Address: 43-45 Barnsley Road Wakefield WF4 4DW

Application number: 2024/93449	
What is the application for?:	Variation of condition 2 (plans) on previous permission 2019/92238 for demolitio
Address of the site or building:	Land at, Westfield Farm, Barnsley Road, Flockton, Huddersfield, WF4 4DW
Postcode:

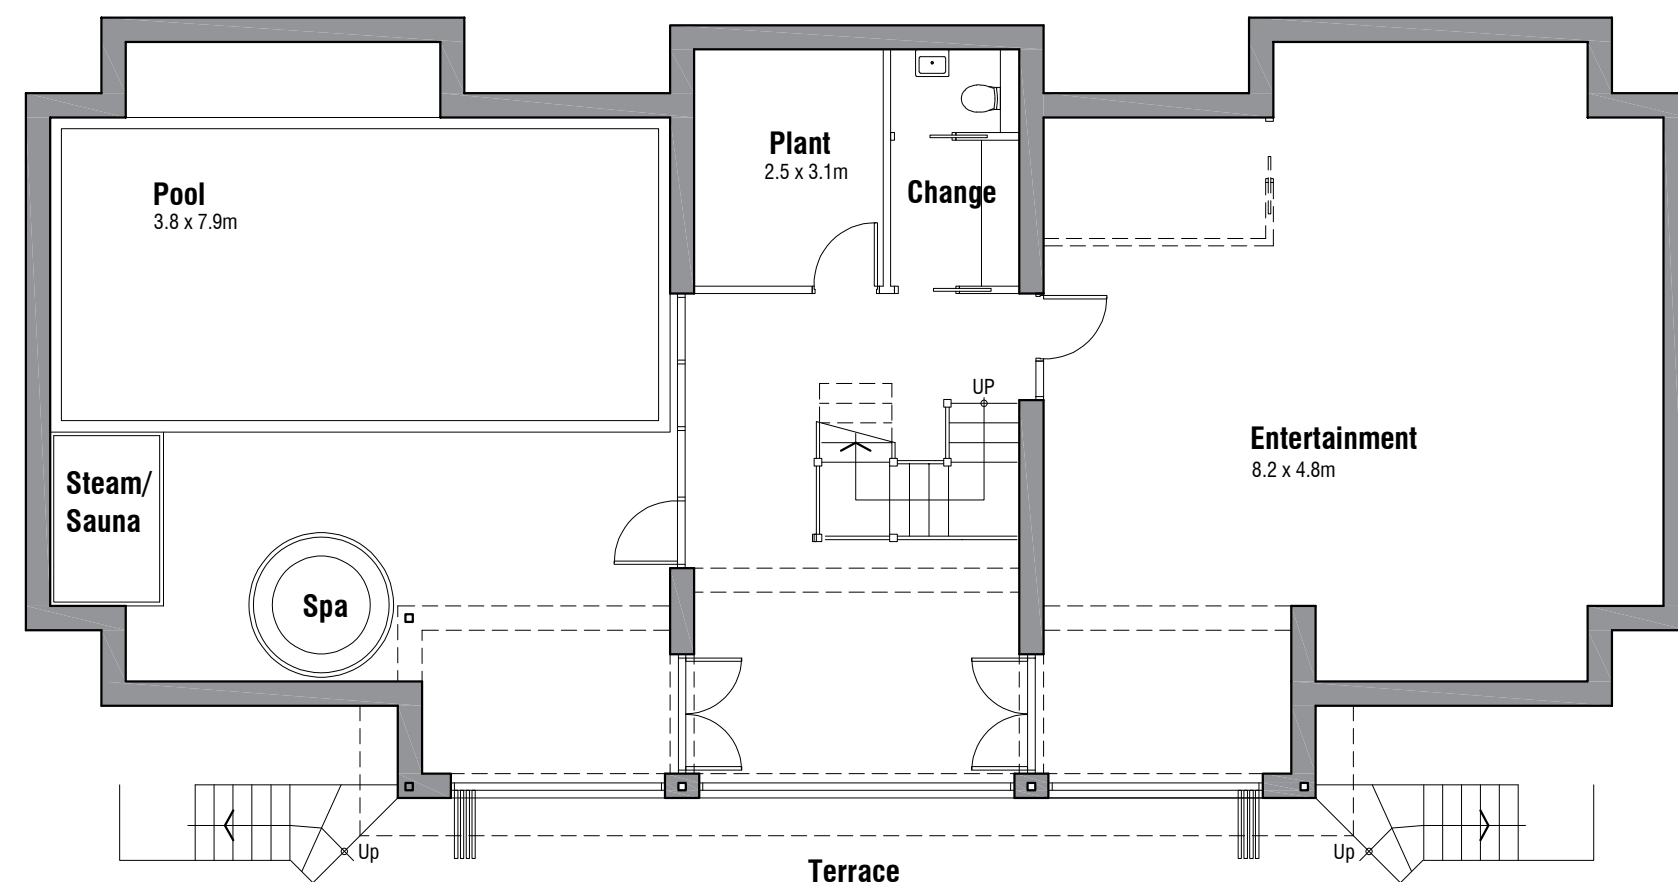
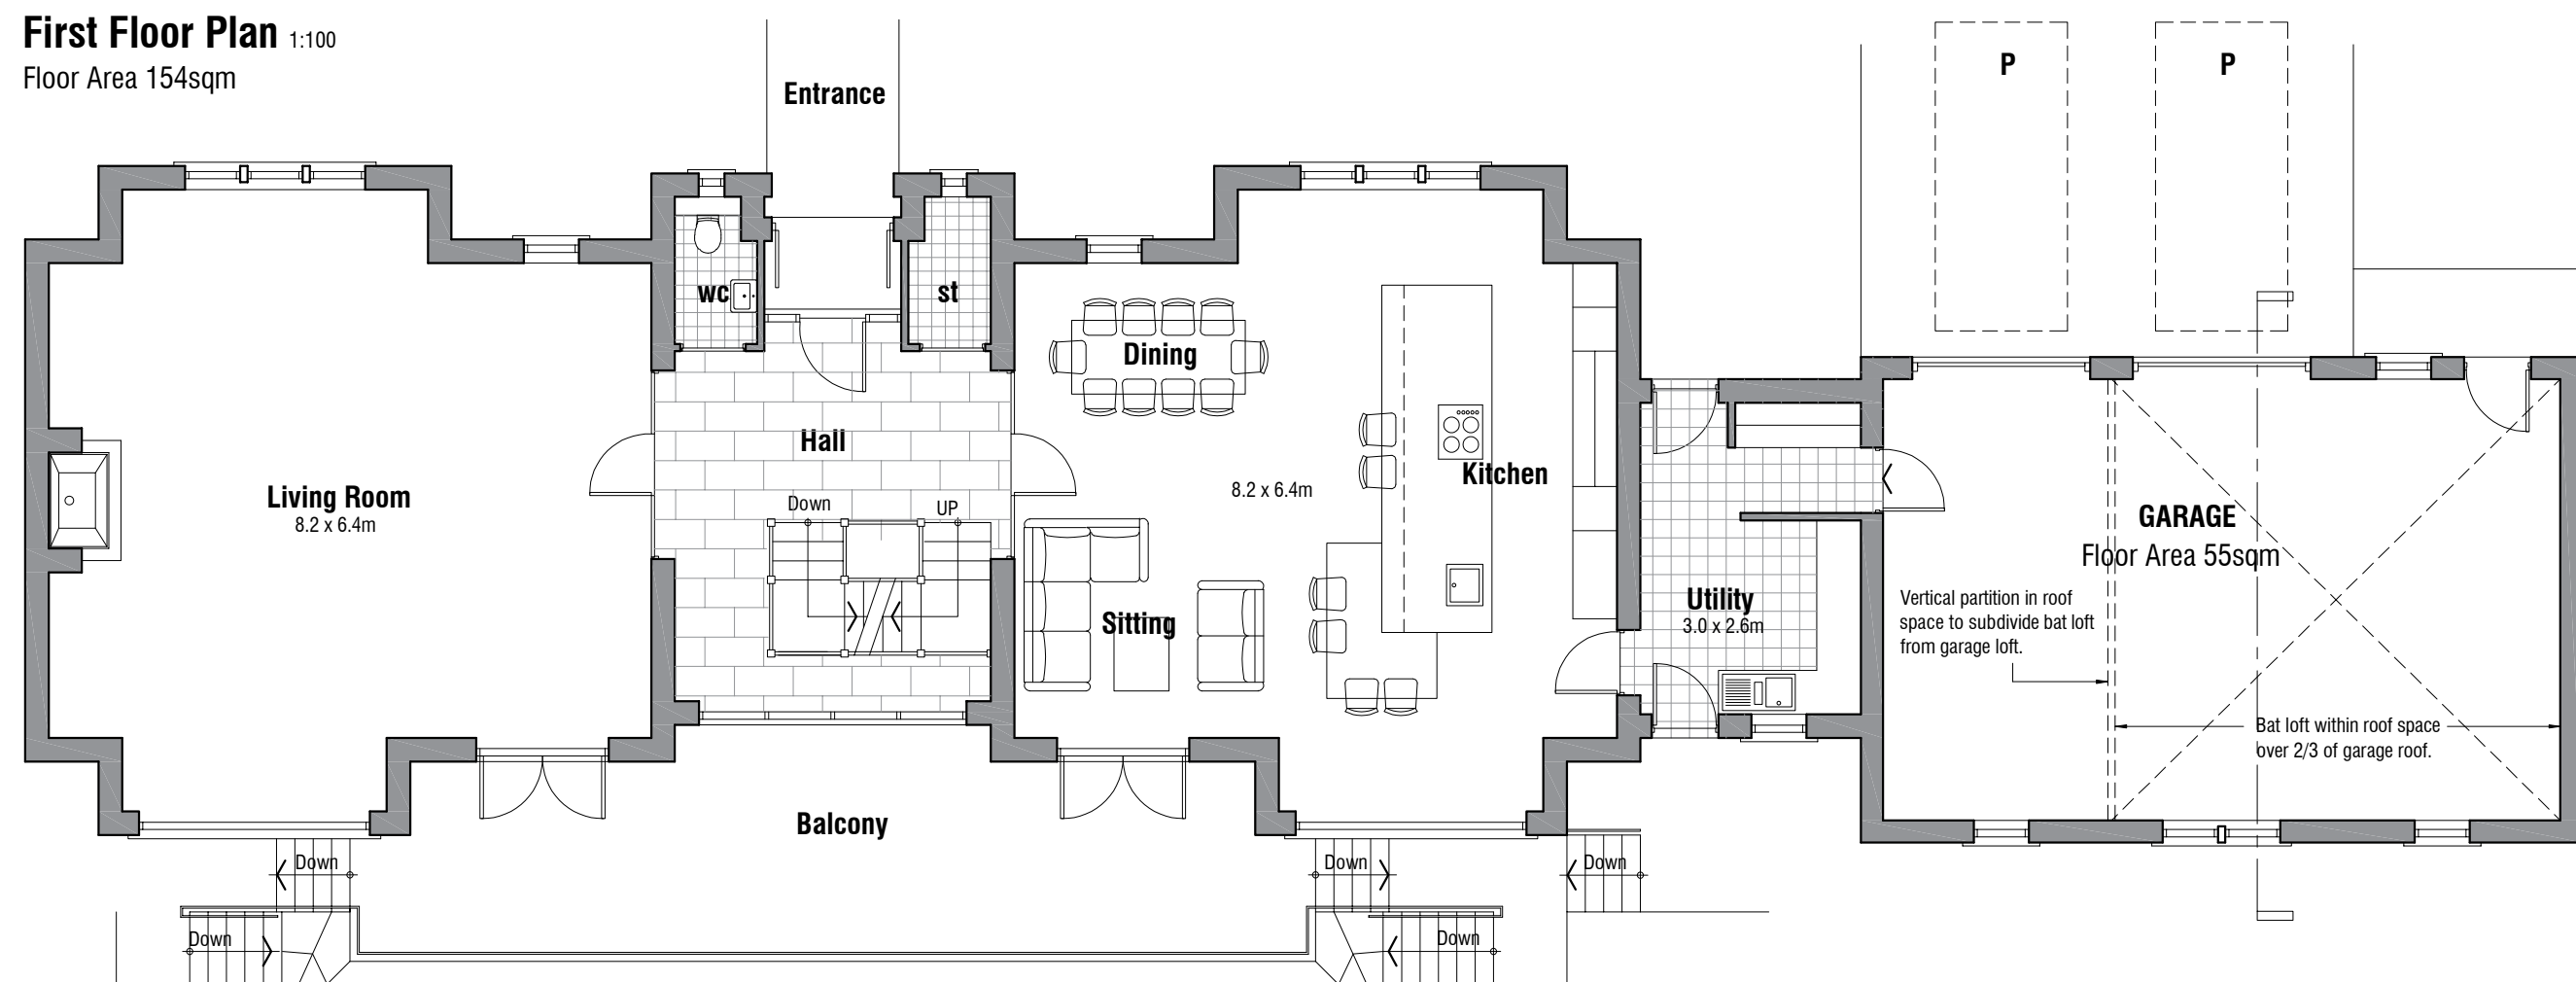
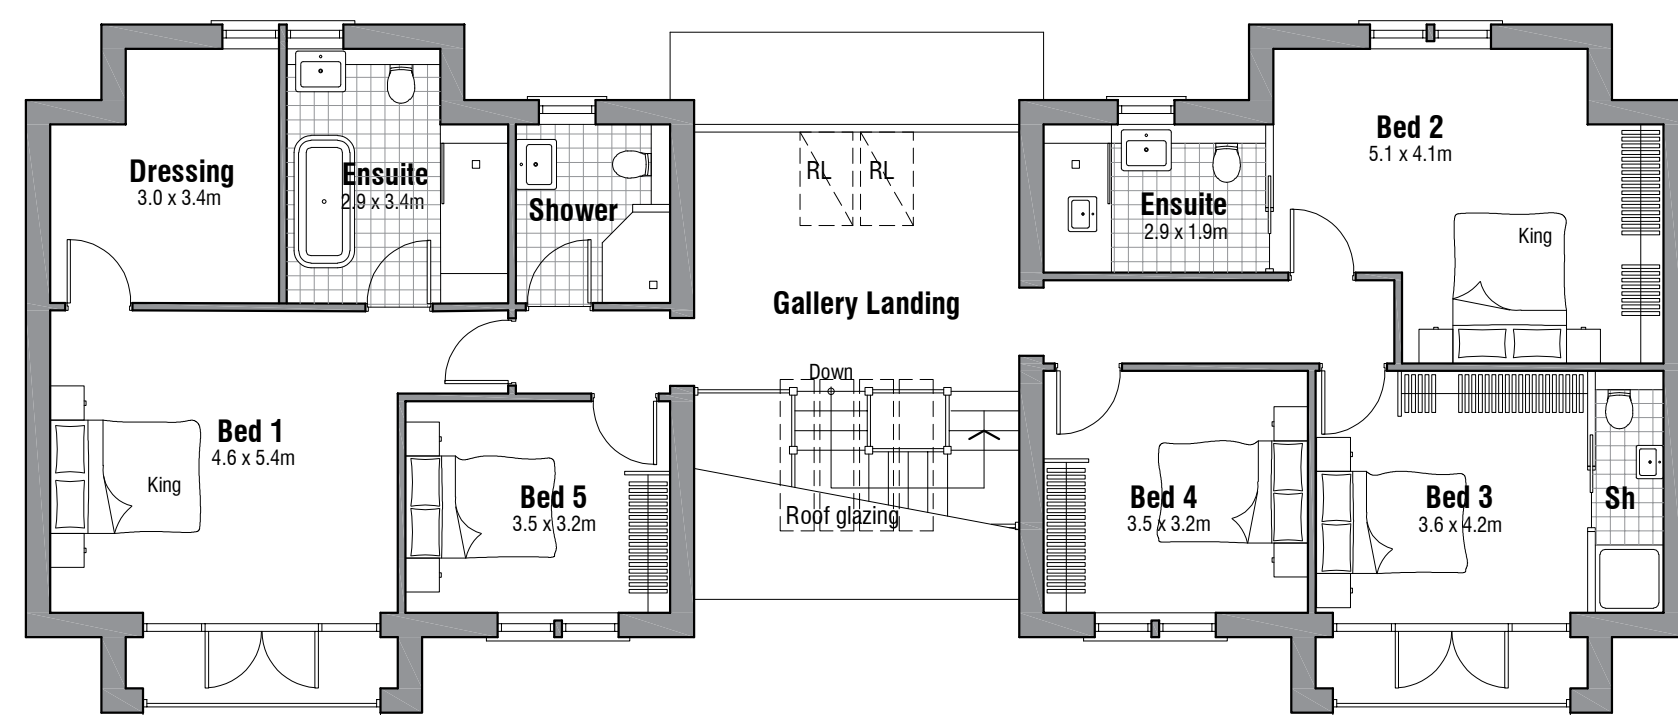
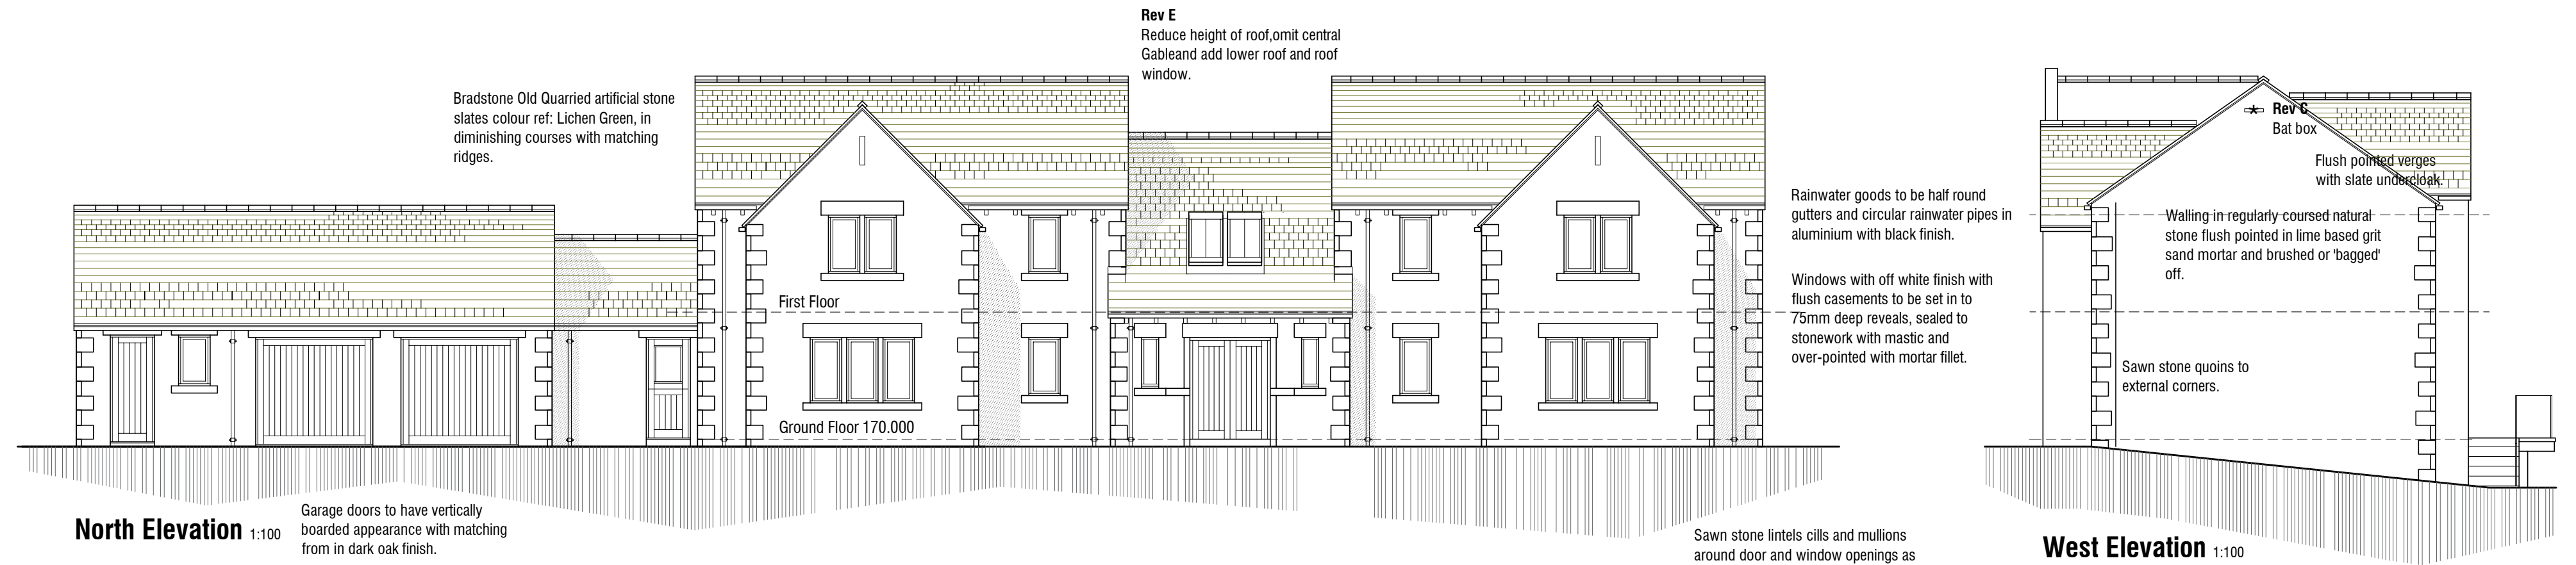
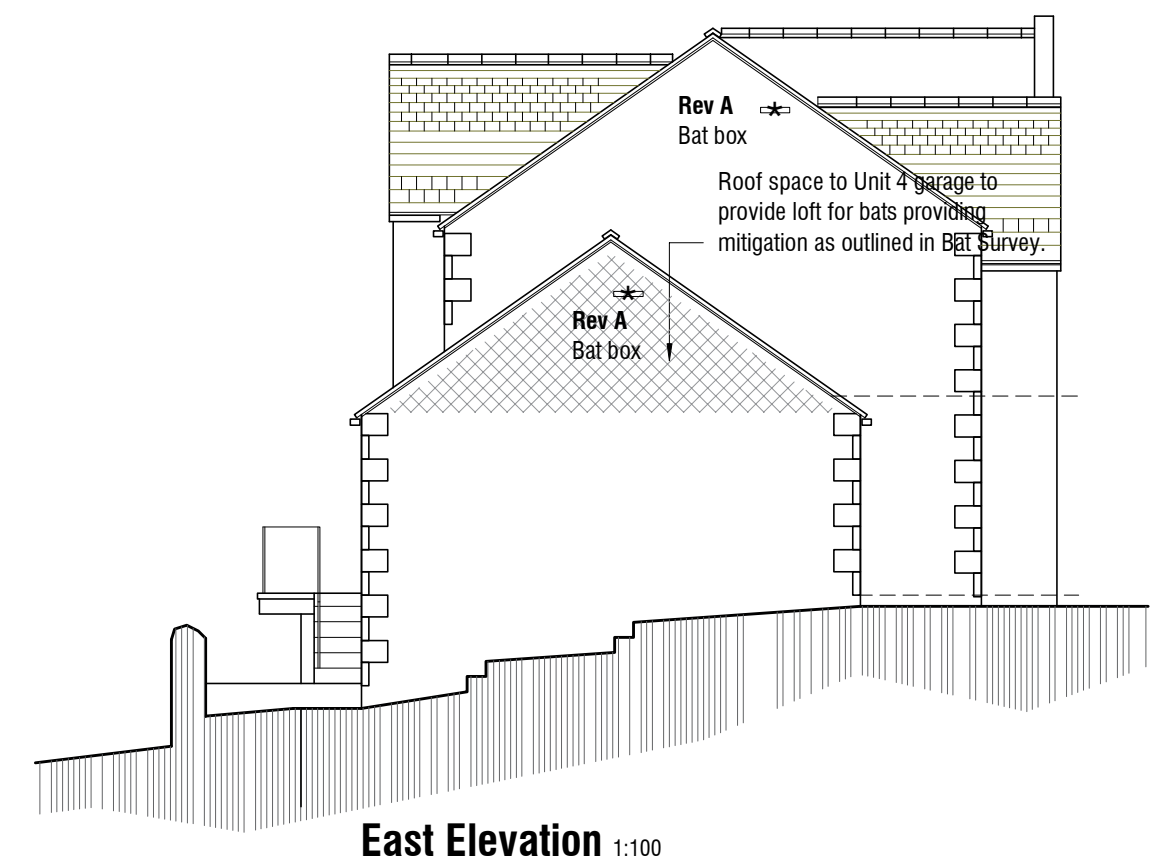
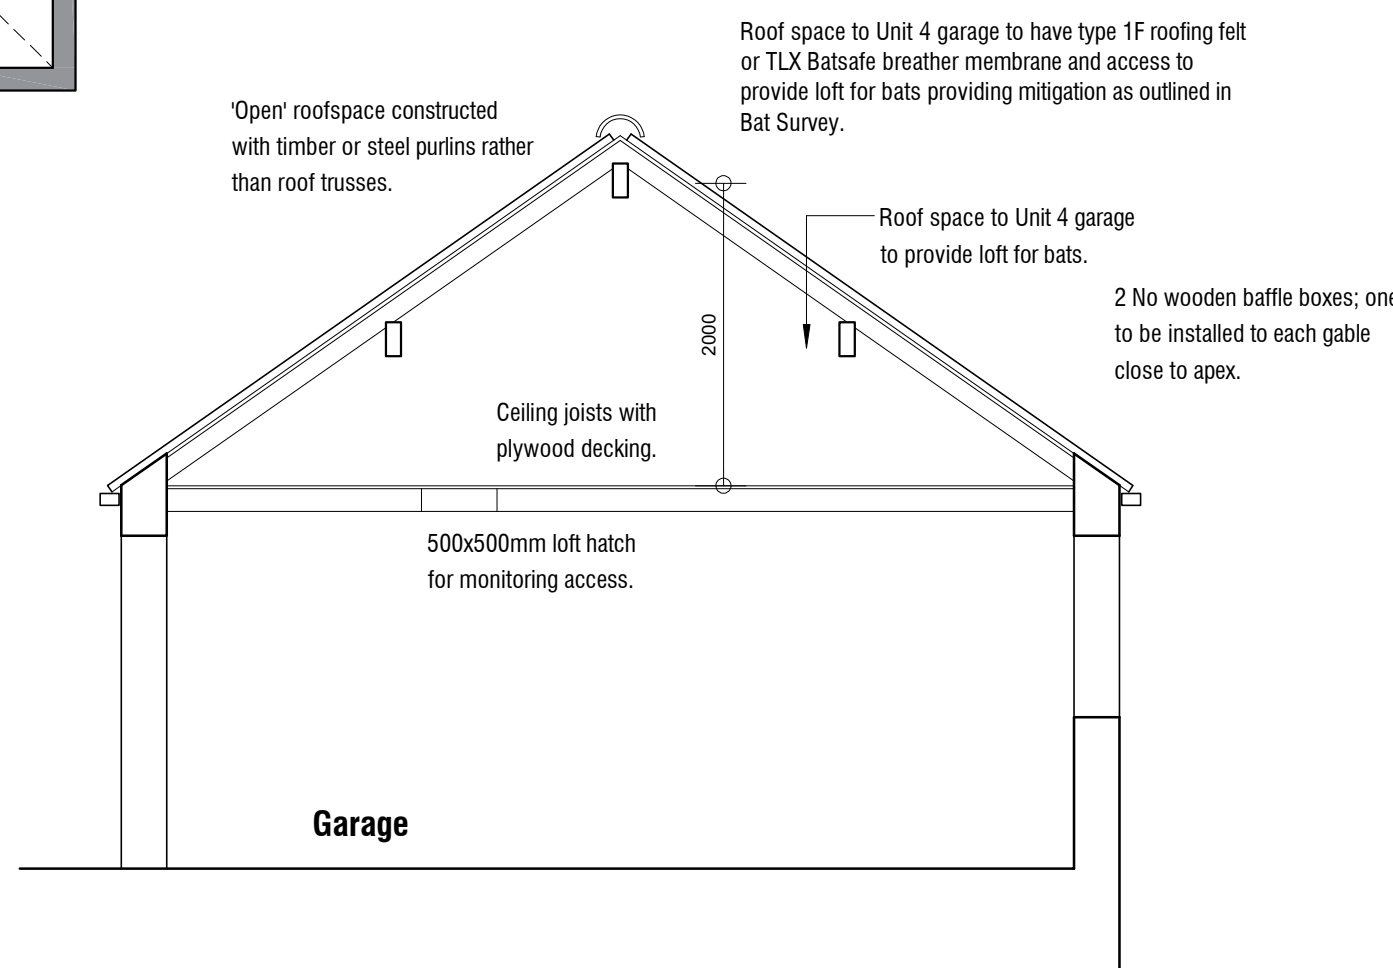
Type of comment: An objection	
Do you wish your comments to be published on the website anonymously?	No
The previous plans for this development was for 4 houses. Now the changes are for 2 houses at 3 levels. This new plan means the property's will be higher than the previous house that has been demolished. This extra level will have a considerable impact on the view from our property and so I need to speak with the planning officer and have clarification on the height of the new building in relation to old building.
